MASTER DEVELOPMENT DRAINAGE PLAN & FINAL DRAINAGE REPORT

MONUMENT ACADEMY

Engineering Review

**JPS Project No. 040201
PCD File No. SP-19-
PPR-19-009**

DETENTION POND M3
PLAN & DETAILS
SCALE: AS SHOWN

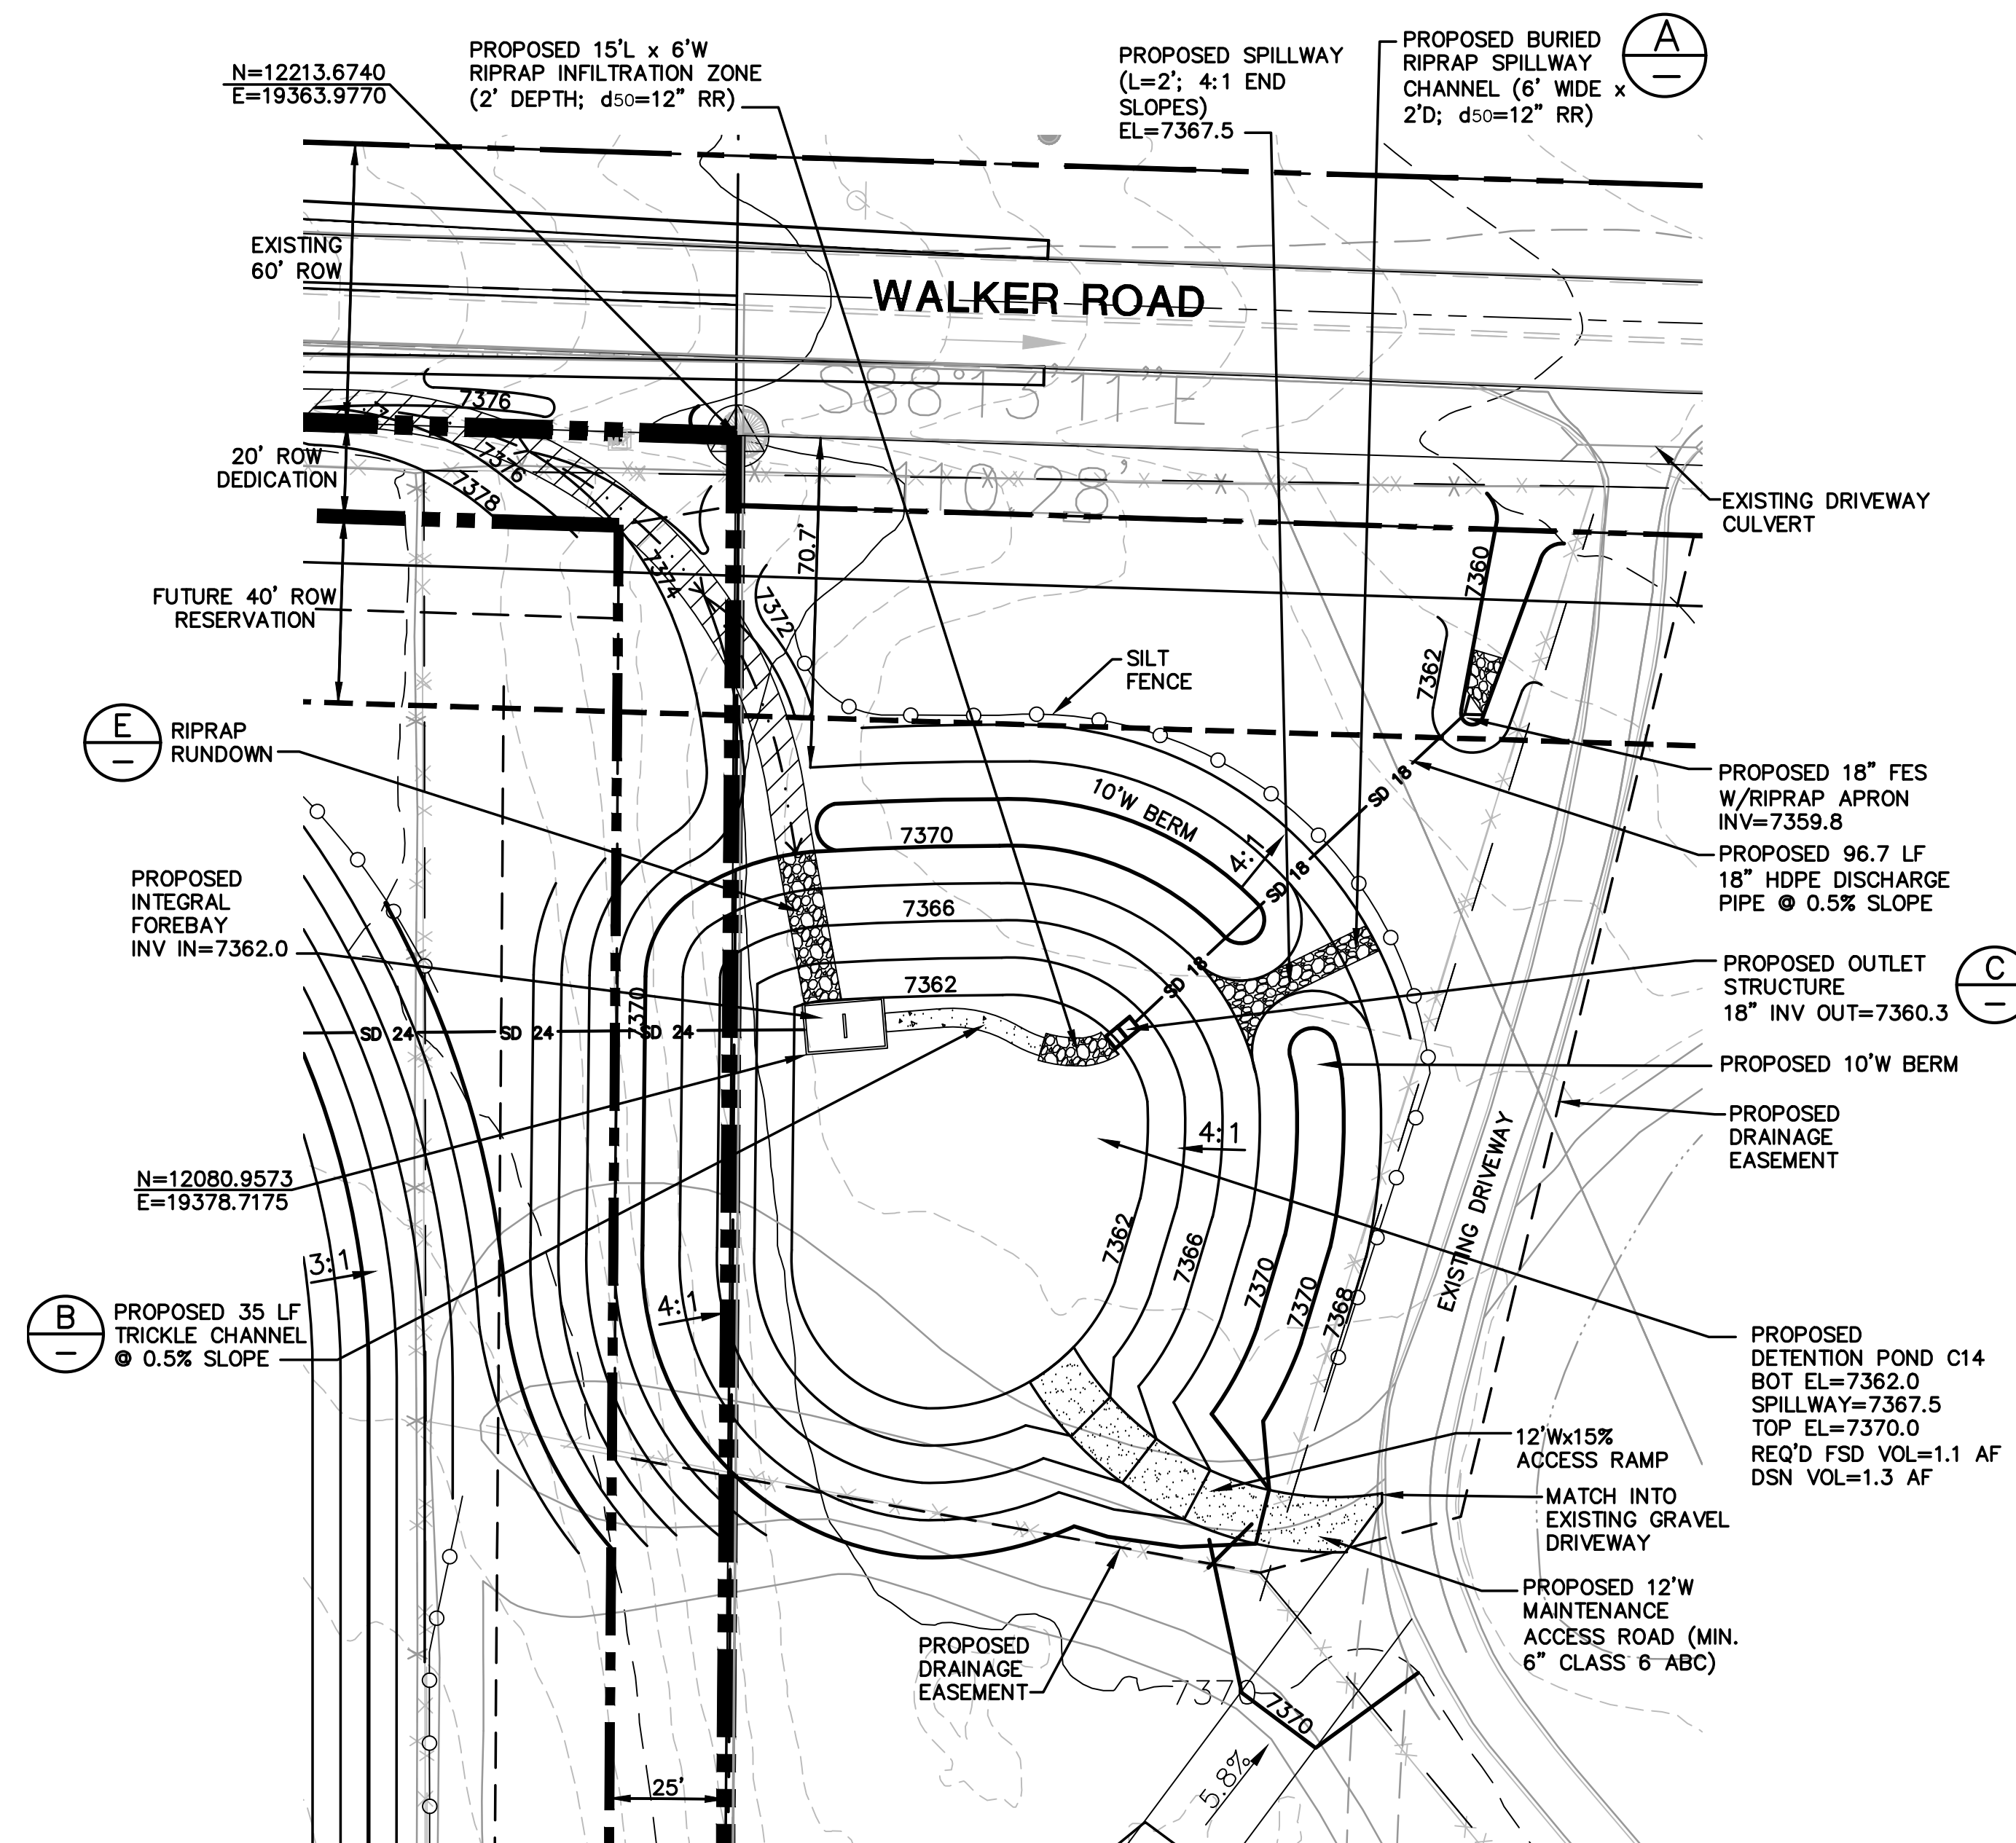
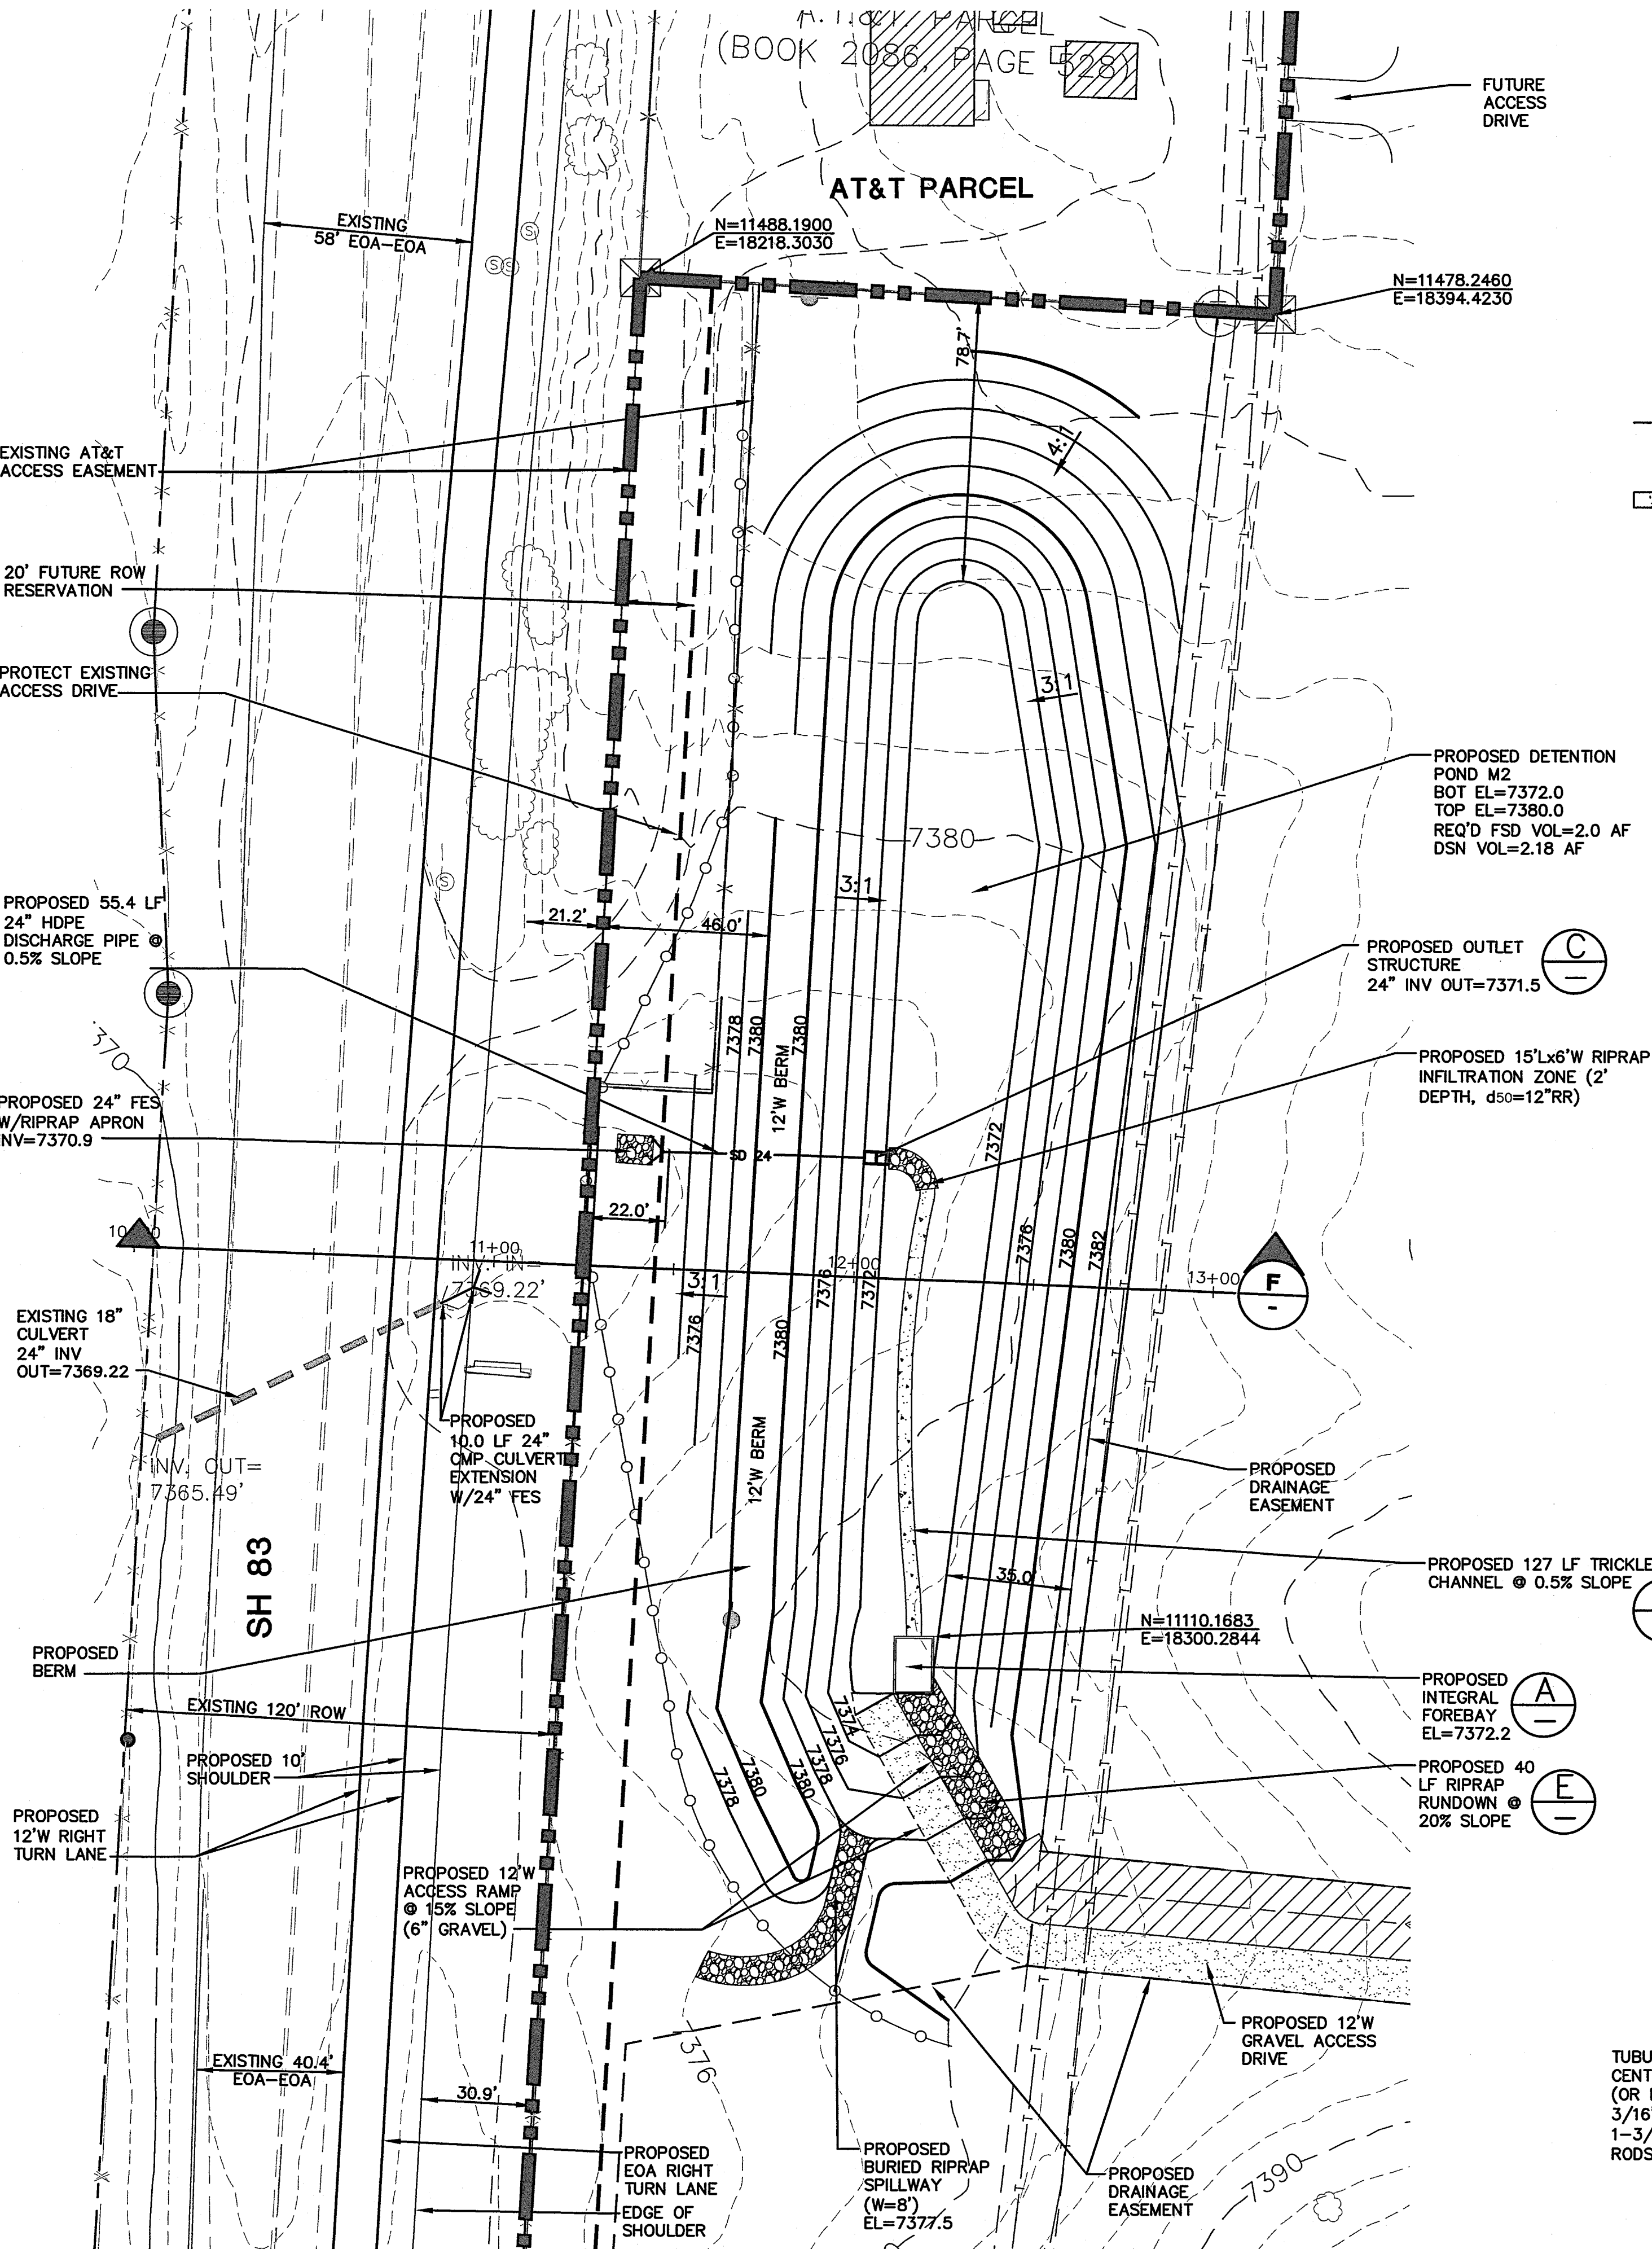
Describe pond inflow/outflow and volume attributes.
